<b>Your Reference</b>	SSD 8800
<b>Our Reference</b>	NCA/8/2017
<b>Contact</b>	Mark Leotta
<b>Telephone</b>	9806 5600
<b>Email</b>	mleotta@cityofparramatta.nsw.gov.au

21/03/2019

**RE: Request for EIS Comments – Parramatta Leagues Club Hotel at 1 Eels Place, Parramatta (SSD 8800)**

5.2 View Impact Analysis

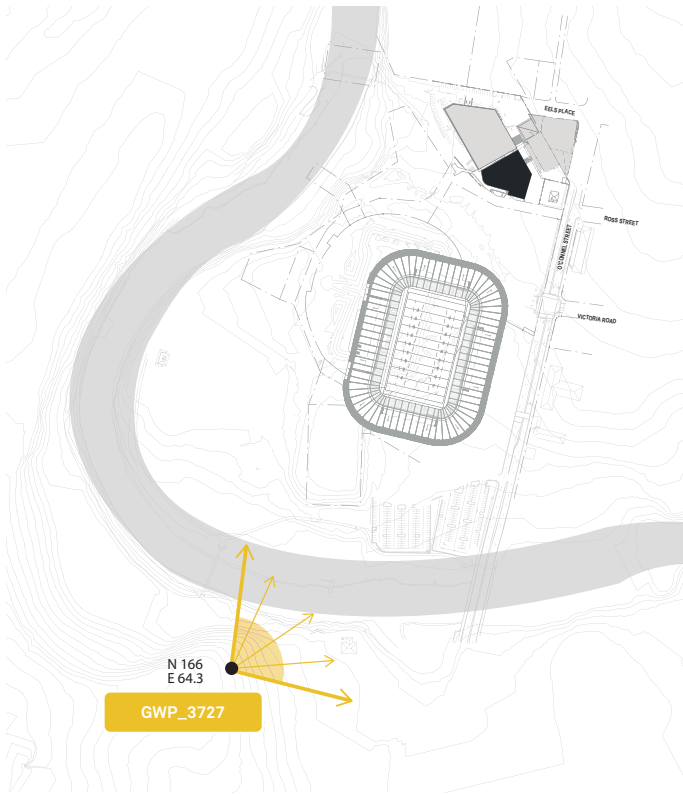
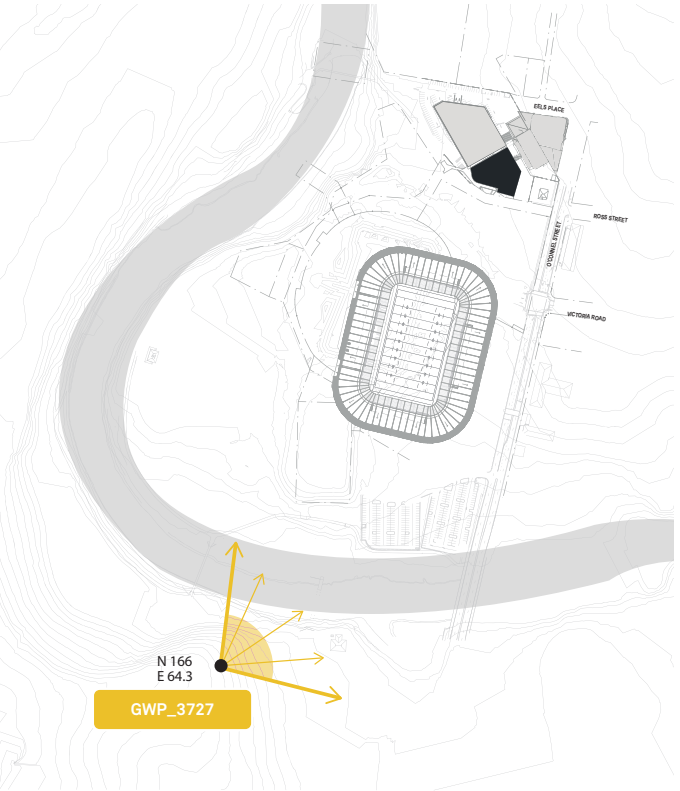
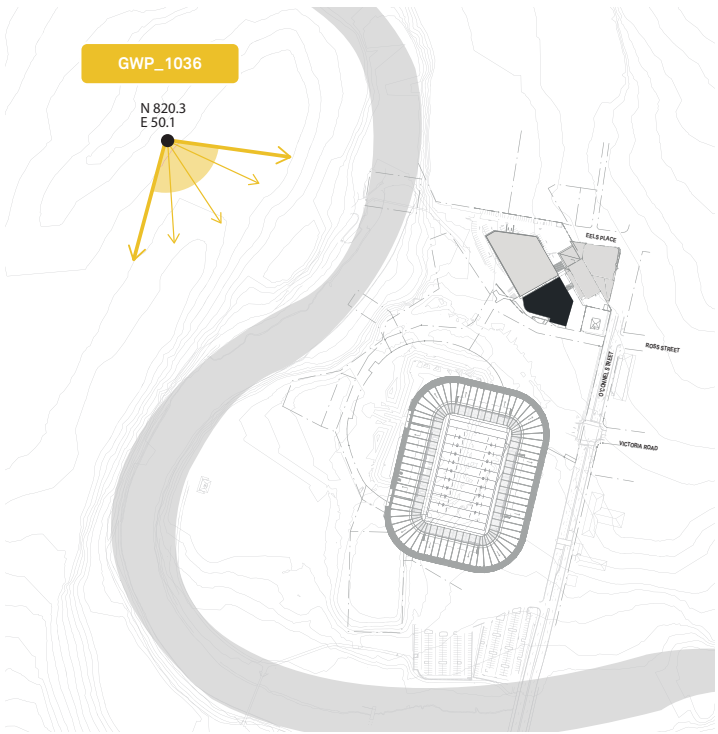
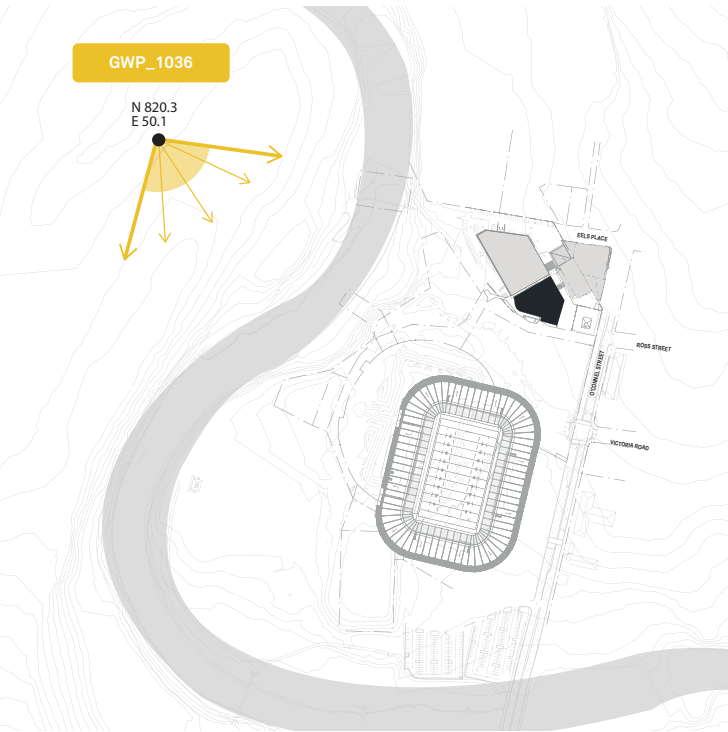
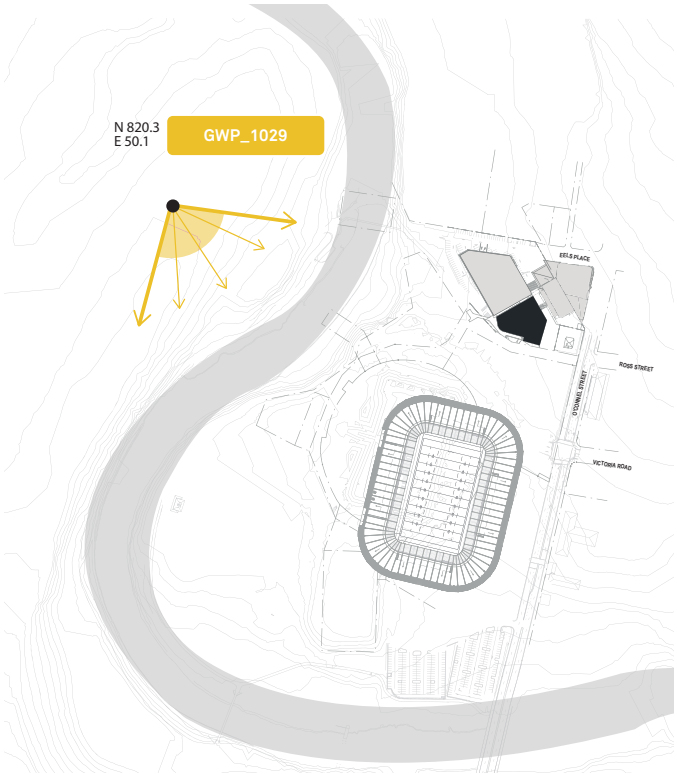
The development must comply with the Park Edge Special Area built form controls Area A1 – Parramatta Leagues Club Site – within *Parramatta Development Control Plan 2011* apply to this development. The relevant controls require:

- (a) At least 80% of the building height to be contained below the level of the surrounding tree canopy of Parramatta Park when viewed from any of the key viewing locations shown in Figure 4.3.3.7.7. Any building element must be oriented so as to minimise the visual impact from these locations.
- (b) External building materials must be muted in colour with matt finishes to minimise contrast with the park surrounds and be complementary to its setting.
- (c) Signage on the upper level of buildings must not face the Domain of Parramatta Park.

The Applicant's Statement of Heritage and Visual Analysis (Appendix G) responds to this particular issue in part. When considering the analysis supplied by the applicant, the view corridors assessed indicated that the proposed development could meet the controls of Area A1.

**Figure 2 (Left)**– Proposed Interstitial Timber Louvres (Hassell, Design Report)

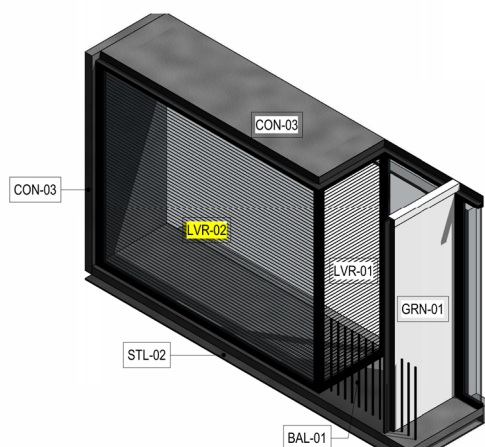
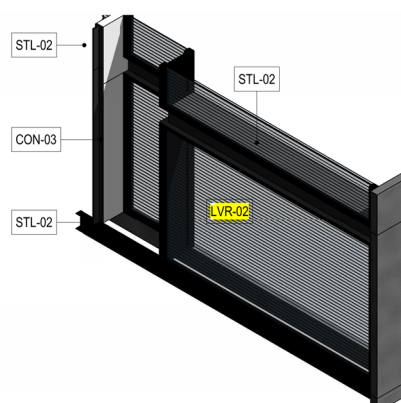
The architectural drawings indicate interstitial timber louvres within all glazing and operable windows to hotels rooms. This provision is supported by Council and should be referenced within the ESD report.
